Good afternoon Ellena,

Council generally concurs the comments provided by Murray River Council, dated 22 July 2024, and is cautiously optimistic as to the social and economic benefits that a project such as this can bring to our community.

Council generally accepts that the EIS has discussed a range of matters in conceptual terms as previously communicated to the Dept and the Proponent. It will be important for the proponent to engage with Council during the preparation of management plans and codes of conduct, as described throughout the EIS, in order to minimise any negative potentialities around social, transport and waste, while maximising community enhancement.

Notes:

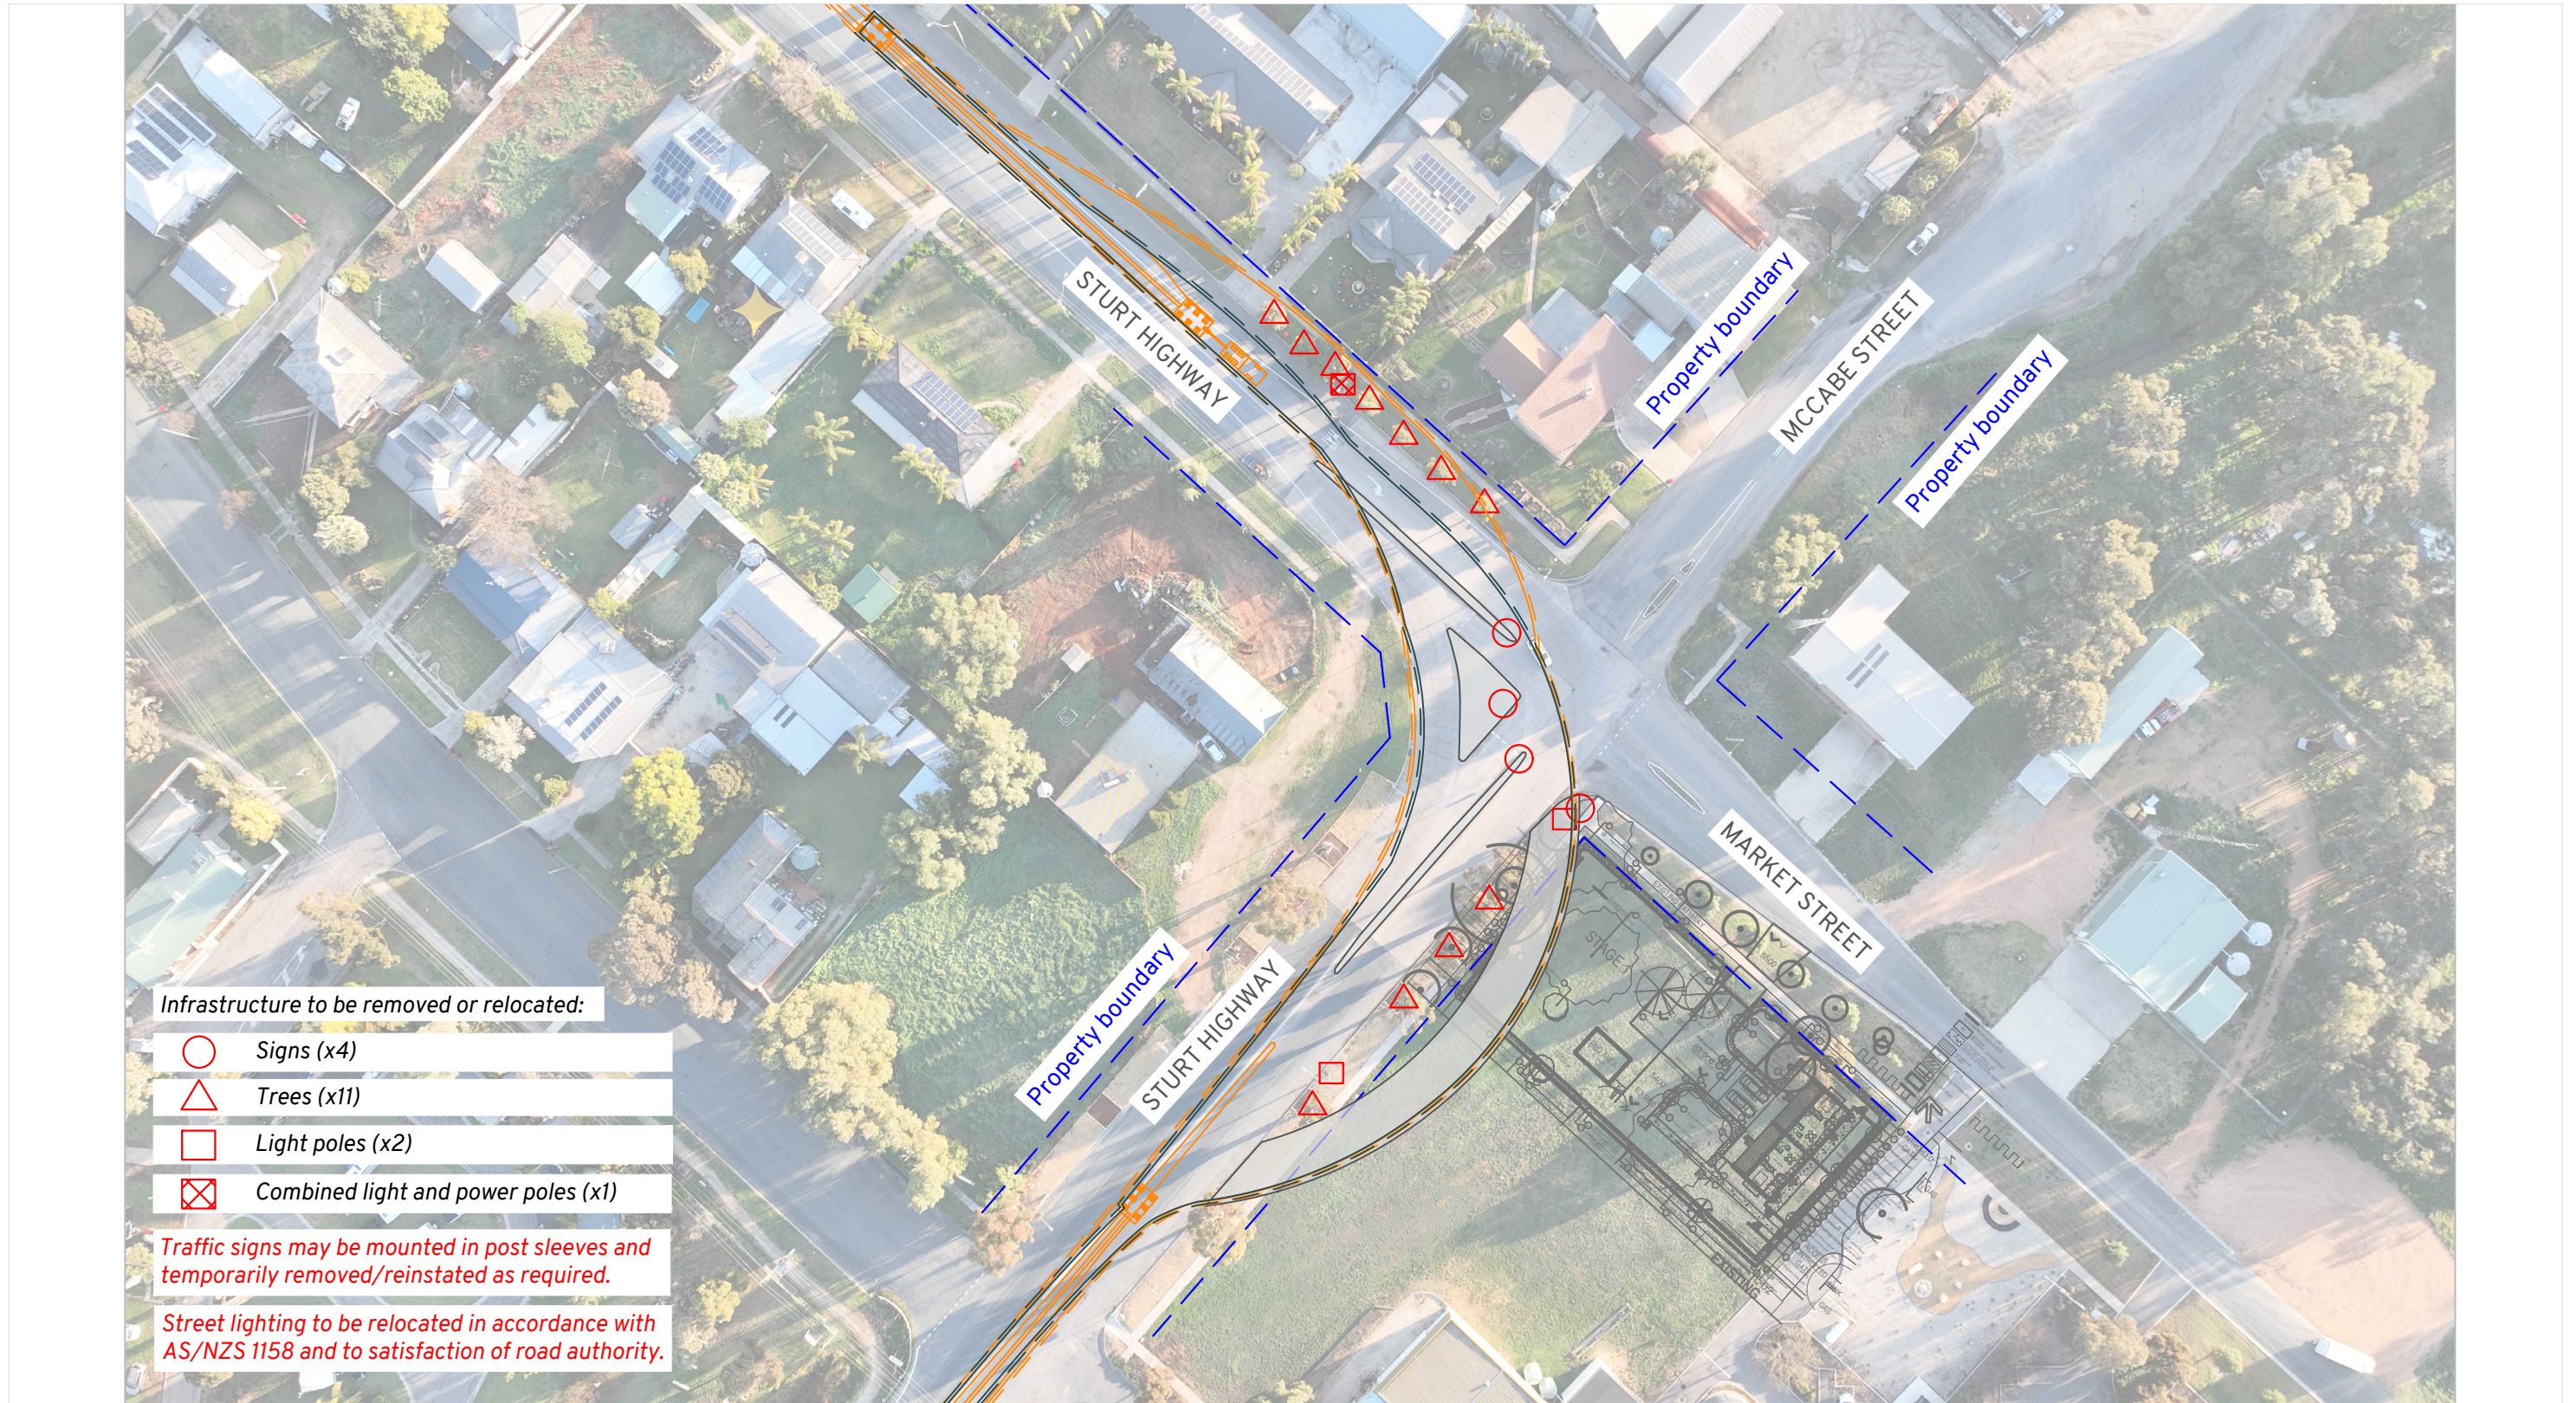
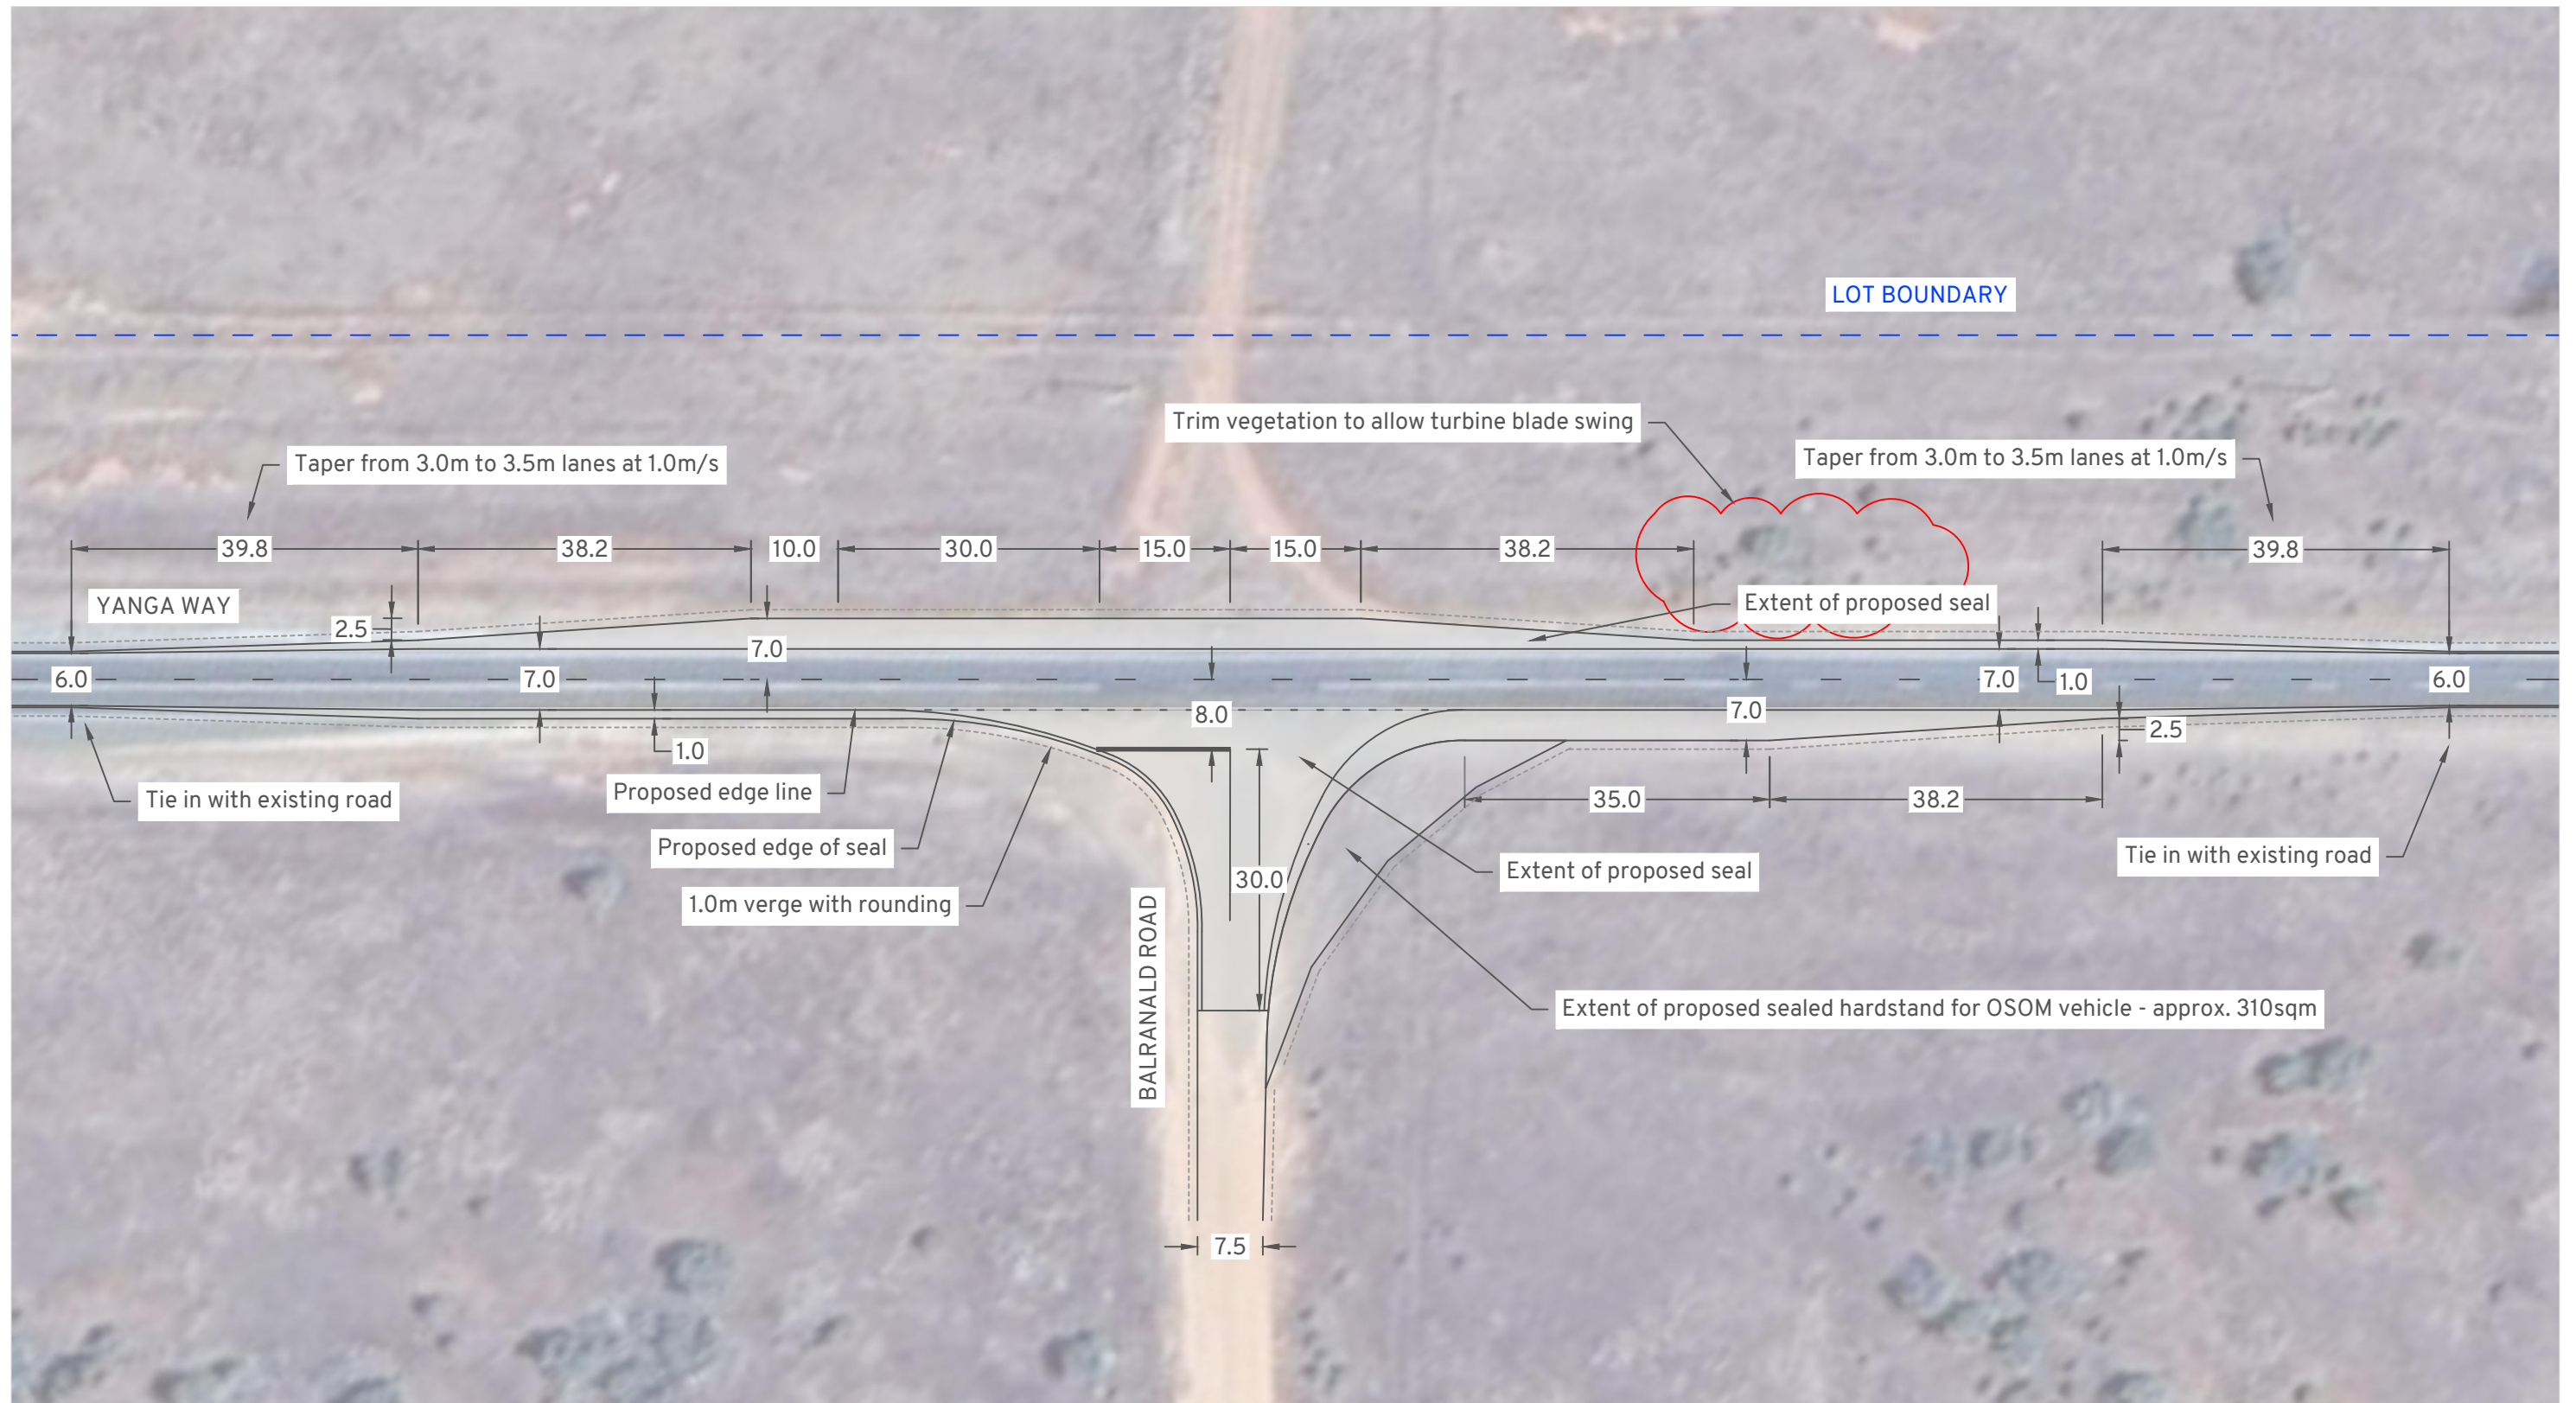
It will be important for the proponent to engage with Council in relation to the Euston roundabout and Market St/Sturt Highway McCabe St intersection treatments around impacts, mitigation and restoration of Council infrastructure at these locations.
